August 28, 1992

RE: REVISED DRAINAGE PLAN FOR ACCESSORIES UNLIMITED (H-16/D57) REVISION DATED
AUGUST 20, 1992

RE: DRAINAGE PLAN FOR ACCESSORIES UNLIMITED
(H-16/D57) STAMP DATED SEPTEMBER 19, 1991

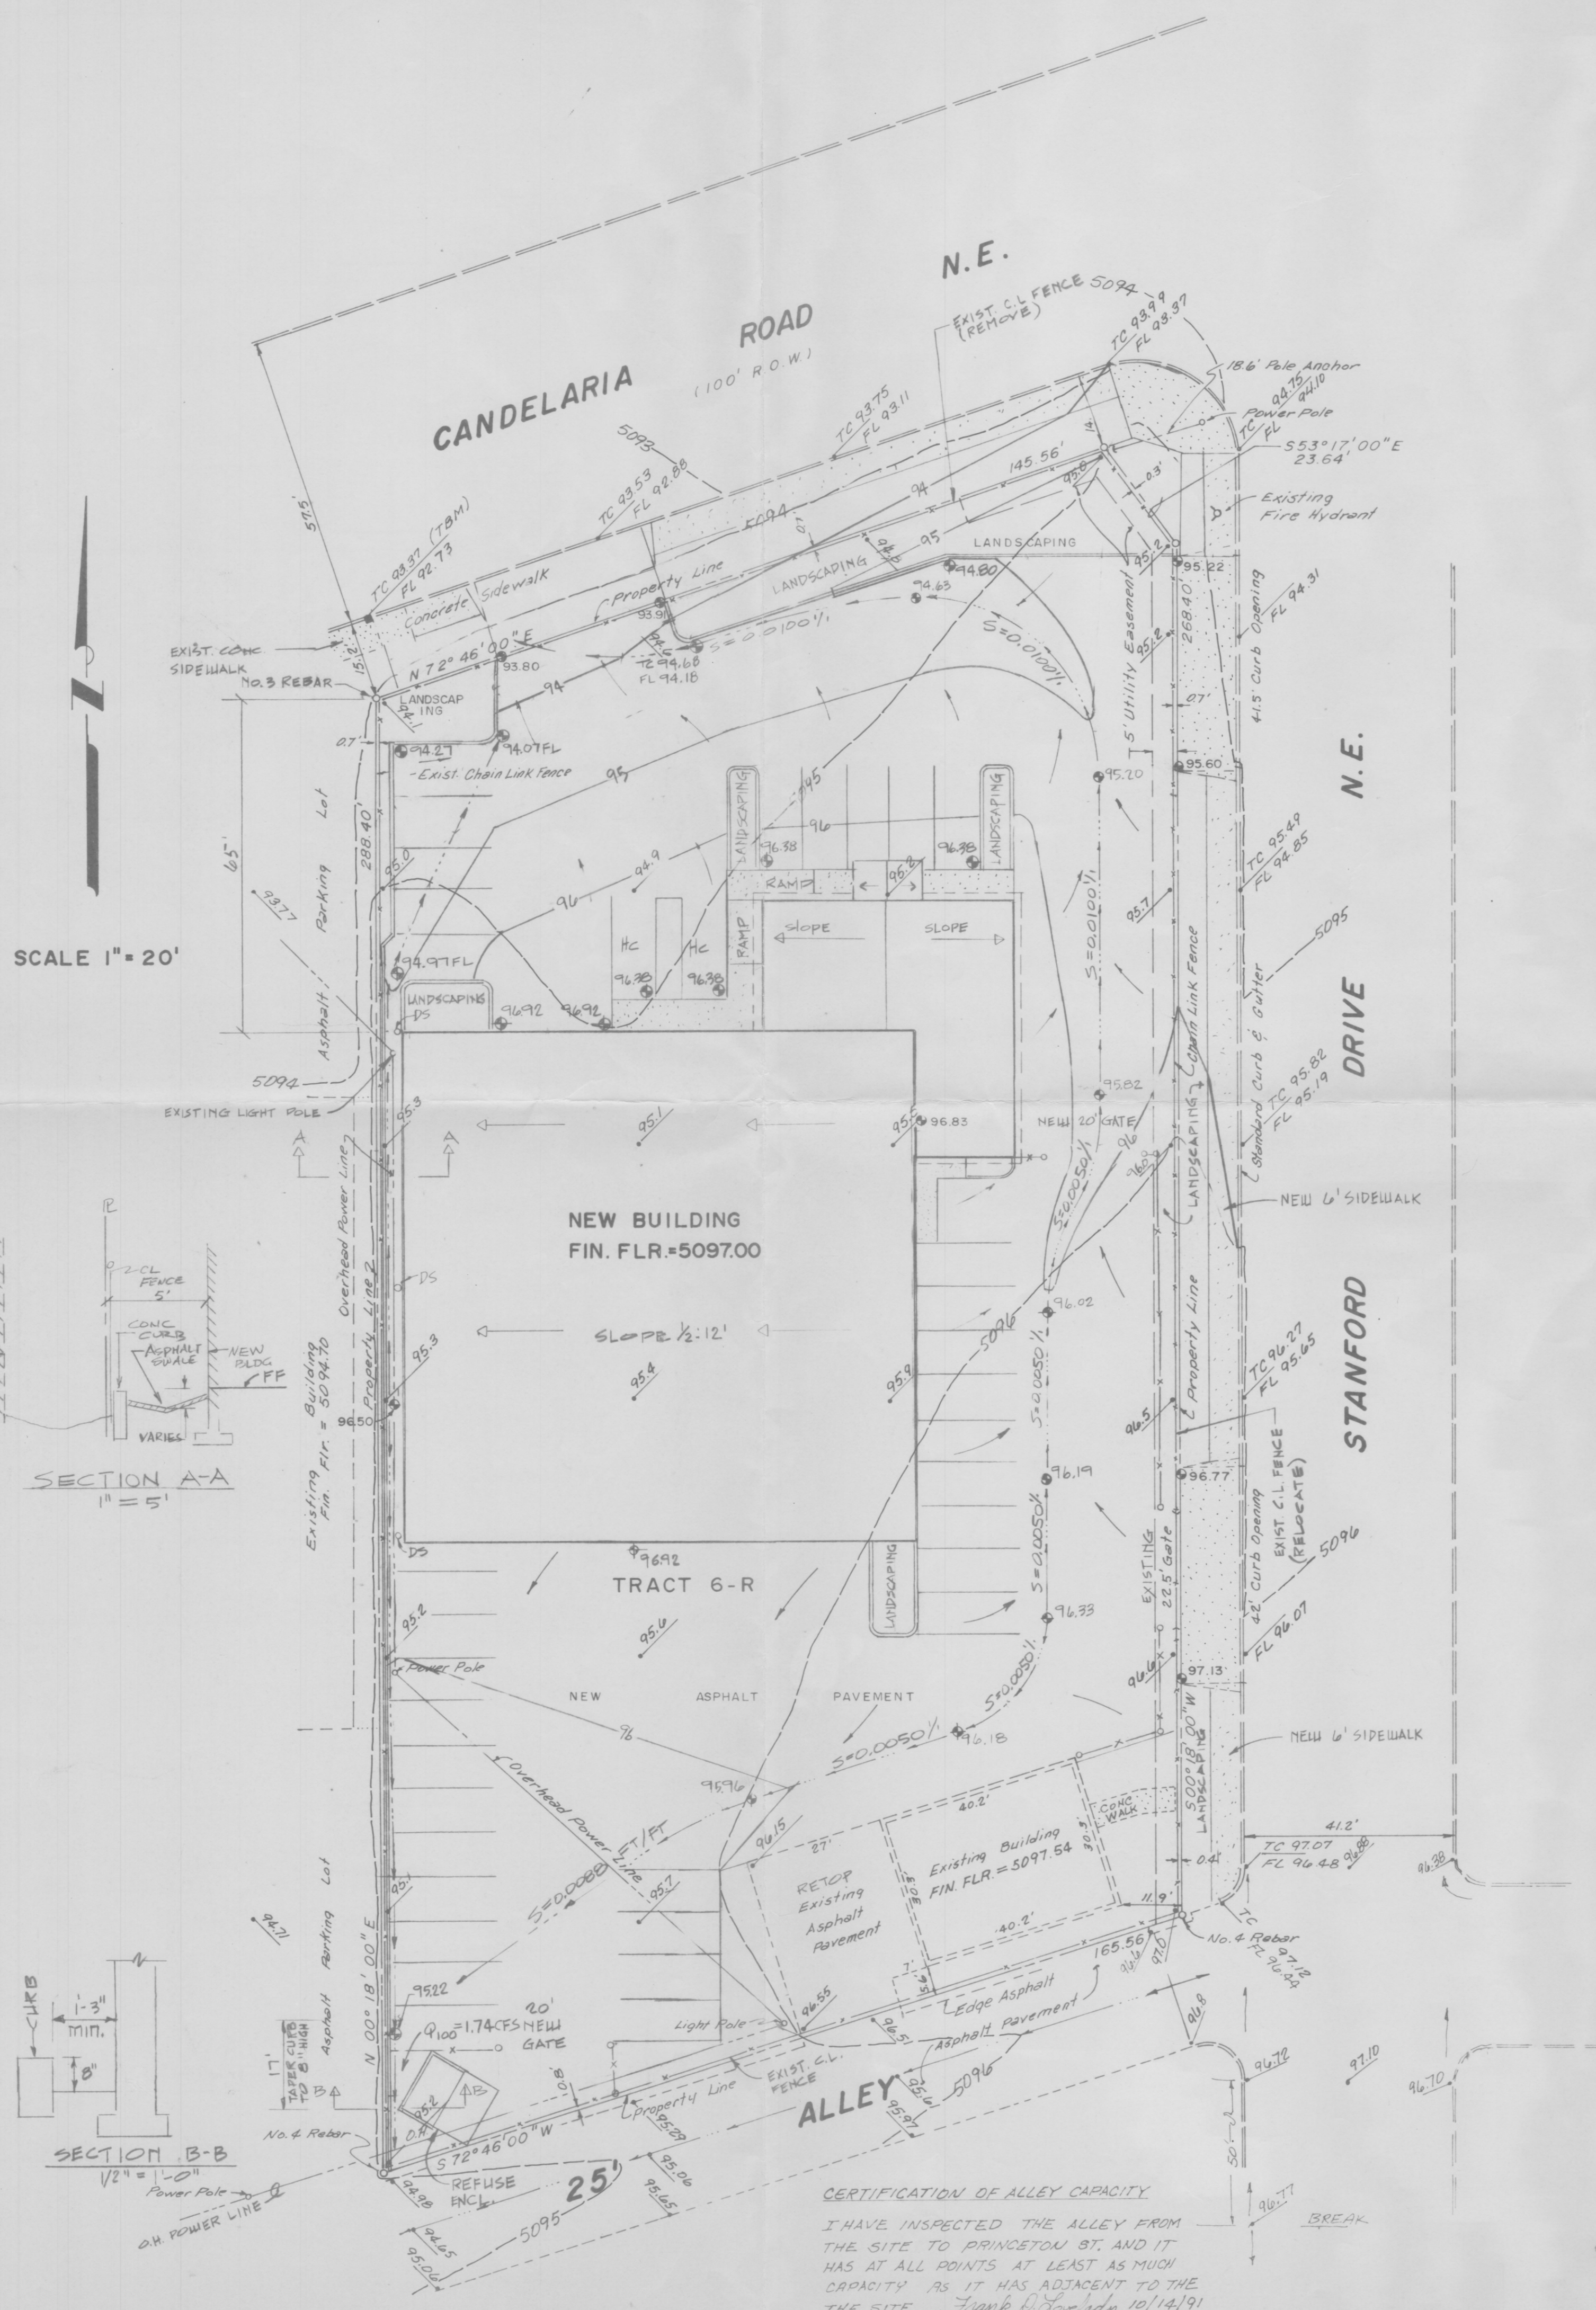
1. Volume computation must be done by the SCS Method.
2. Please evaluate the condition of the alley starting at the site and on towards Princeton. Prior to permitting, the runoff to enter the alley verification must be submitted that no runoff enters other lots from the alley.
3. Verify with spot elevations that no public runoff will enter alley from Stanford Drive, NE.
